Our ref: PS118400-P&M-LTR-011 Request for Additional Info

Health Infrastructure engaged WSP to prepare a Transport Assessment (TA) as part of an Environmental Impact Statement (EIS) for inclusion in a State Significant Development Application (SSDA) for the Children's Hospital at Westmead Redevelopment Stage 2, Paediatric Services Building. The TA (March 2021) assessed the traffic, car parking and loading requirements of the proposal.

RESPONSE TO SUBMISSIONS – TRAFFIC AND TRANSPORT

Scale	1 : 500@A1	Date	19/11/21
Drawn By	LL	Checked By	AF
Project No	19038	Revision	G
Drawing No	CHW-AR-DG-PSB-SSD011

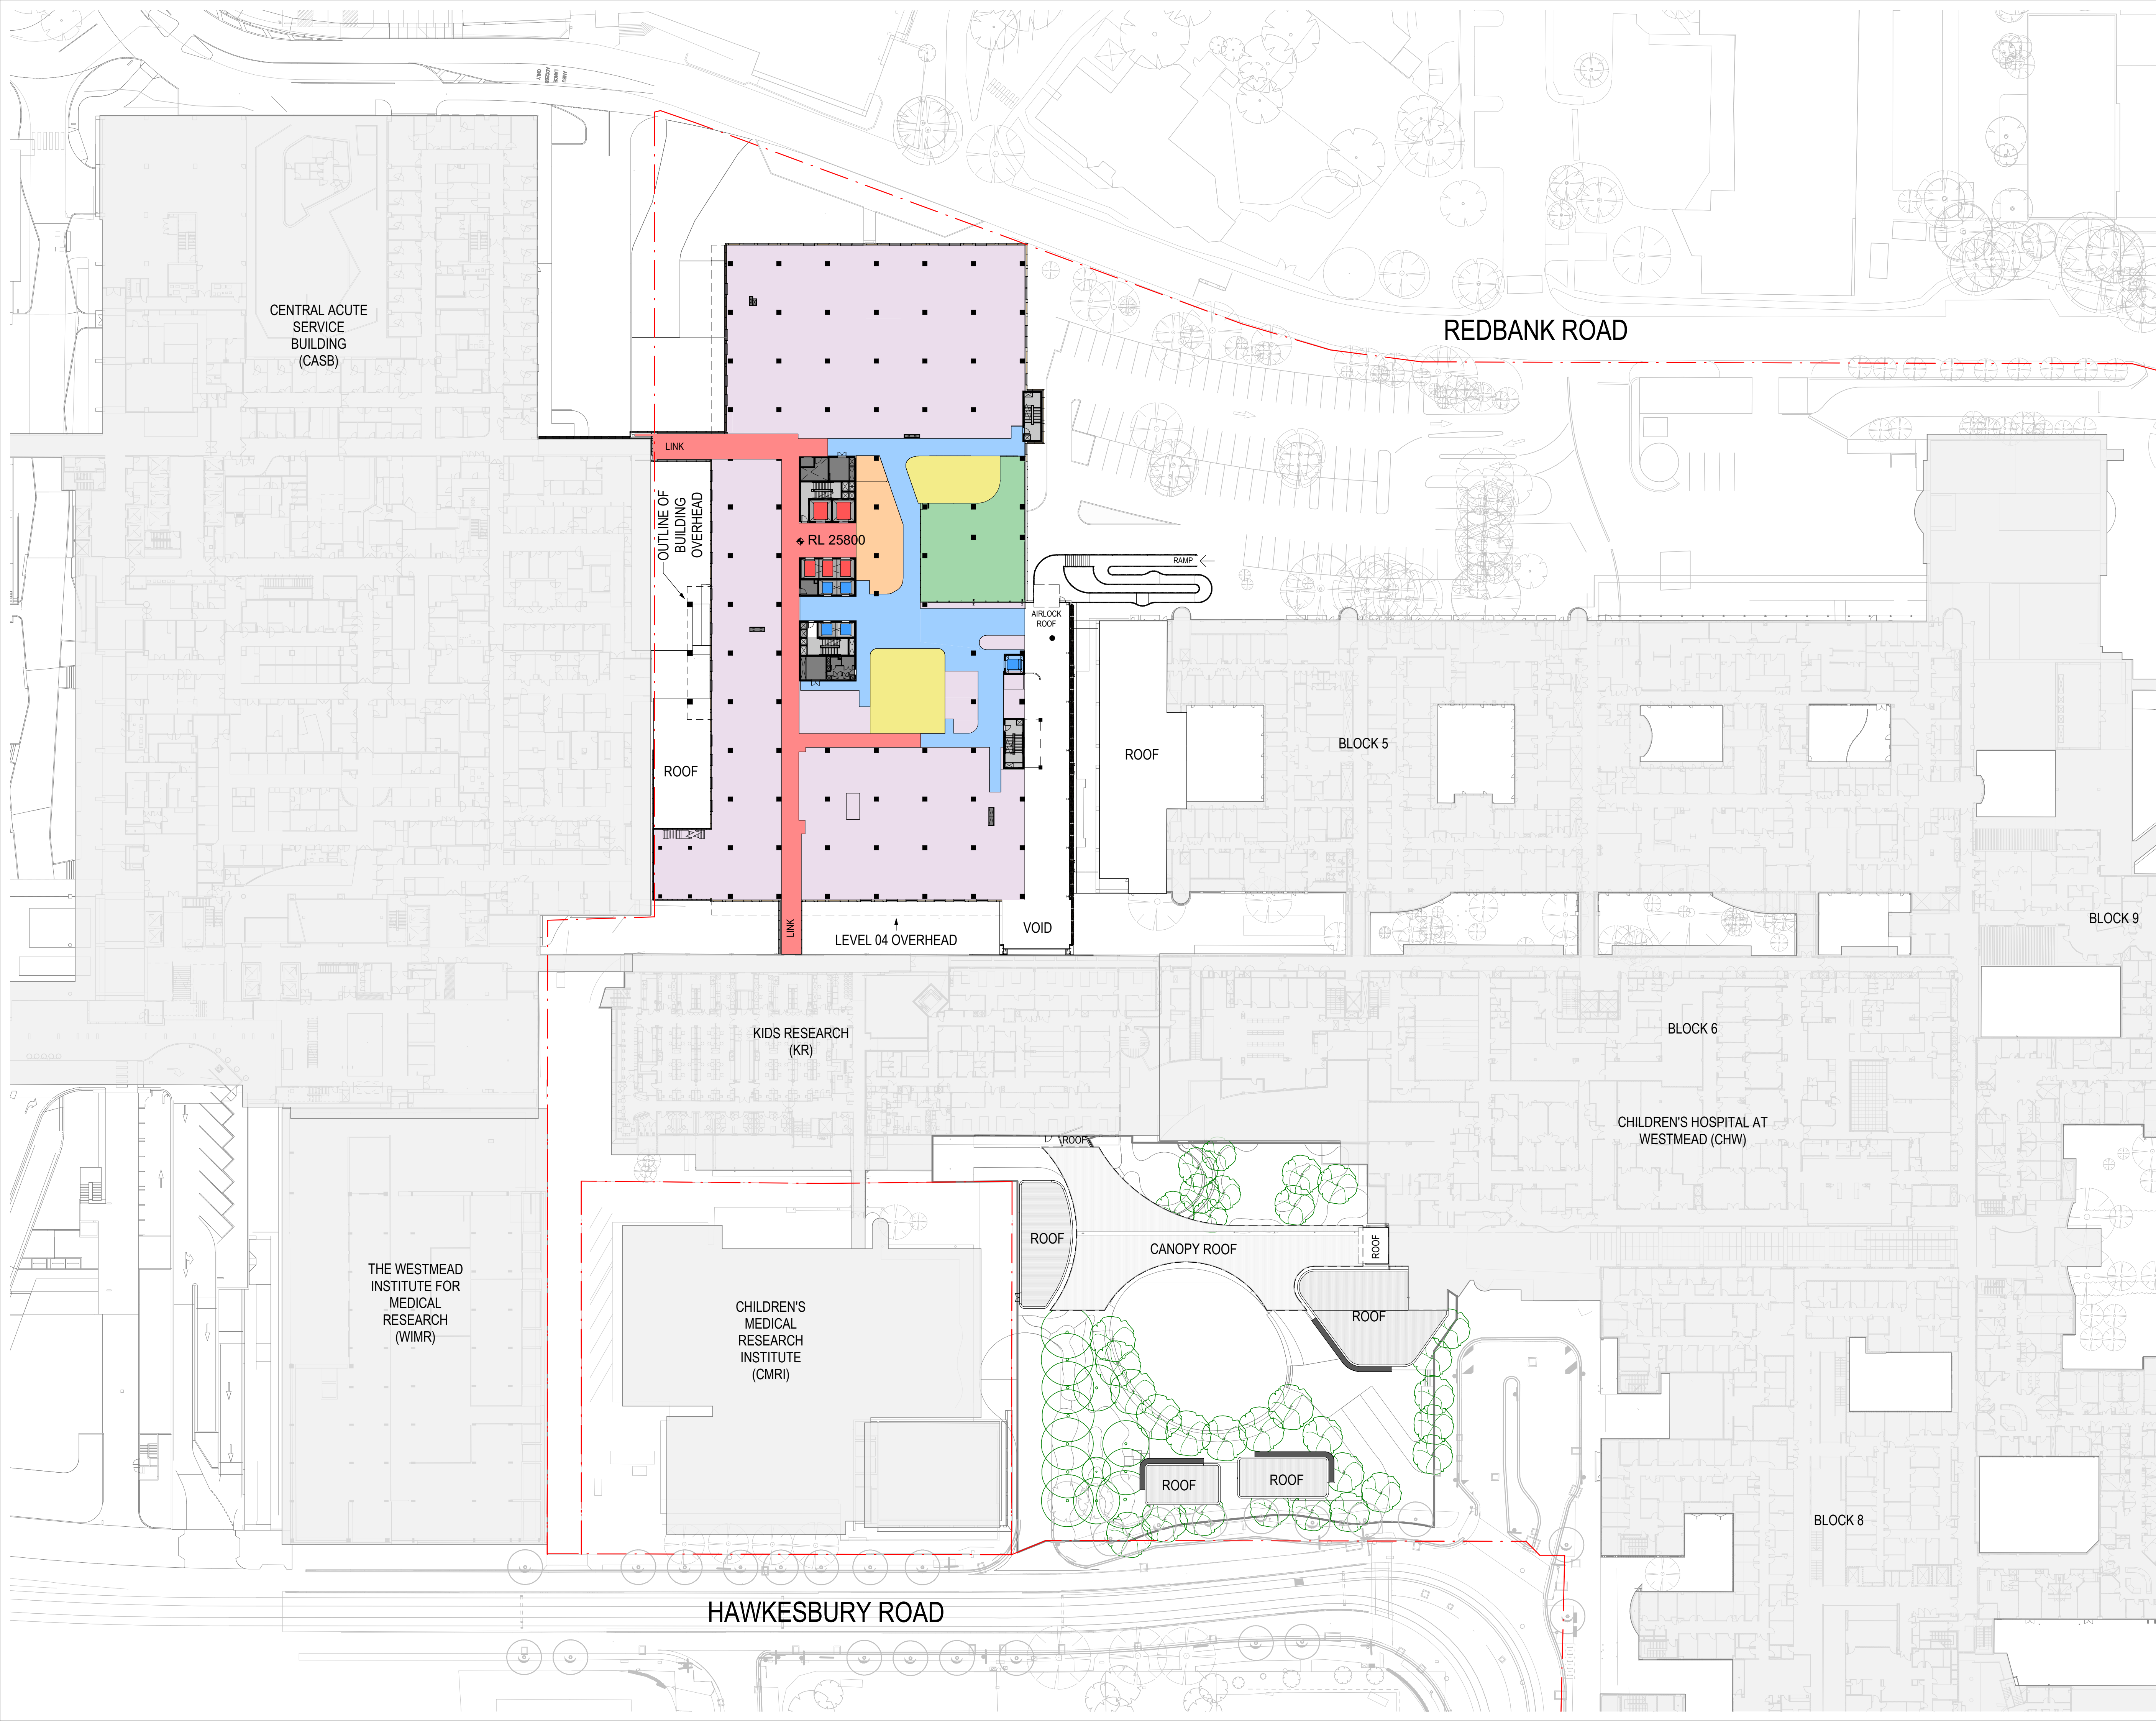
It is recommended that the plans be revised to provide shared areas for disabled parking spaces that is compliant with AS2890.6-2009. Note that bollards are to be installed in accordance with Figures 2.2 and 2.3 of AS2890.6-2009. Furthermore, it is also recommended that plans be revised to include directional pavement arrows/signs to indicate the one-way traffic flow within the car park.

It is noted that the plans submitted (Dwg No. CHW-AR-DG-PSB-SSD011 Rev E) appears to show a concrete median proposed close to the cul-de-sac at the end of the driveway. It is recommended that the concrete median be removed to facilitate loading manoeuvres.

Based on the Level 02 plan (Dwg No, CHW-AR-DG-PSB-SSD011 Rev E), the ambulance bay appears to reduce to approx. 2.2m in width at the adjacent driveway entrance. This width is considered too narrow to accommodate an ambulance vehicle. Aerial images show that the width of the ambulance bay is approx. 3.4m with Keep Clear installed at this location. However, it appears there are no changes proposed to this ambulance bay as part of this development. It is recommended that the plans be amended to reflect the current site arrangements to ensure the bay can accommodate an ambulance vehicle.

As depicted in the image below, shared areas with complying dimensions have been provided for car parking spaces for people with disability. Additionally, the traffic circulation within the car park has been indicated to be one-way in the clockwise direction.

Bollards in the shared area and pavement arrows can be readily included in the car park layout to comply with the Australian Standards (AS2890.1 and AS2890.6 for off-street car park and off-street parking for people with disability respectively).

- A Loading Dock Management Plan for PSB building would be developed as part of the condition of the Construction Certificate.
- A Loading Dock Management Plan for the KidsPark would also be developed as part of the condition of the Construction Certificate. It is intended that deliveries to the retail pods in KidsPark would be undertaken outside of the core operating hours of businesses in the Westmead Health Precinct. Delivery vehicles to the retail pod would also be able to park within KidsPark as shown in Attachment B.

The new PSB Ambulance Bay on L02 is accessible via the existing CASB driveway. The bay is a dedicated space and does not provide access to the parking level. The proposed dimensions for the Ambulance Bay are width: ~7.6m, Length: ~12.8m to allow for the ambulance vehicle to park and for sufficient stretcher movement, as per the below markup. There is no change proposed to the existing CASB Ambulance Bays or the access driveway as a result of this.
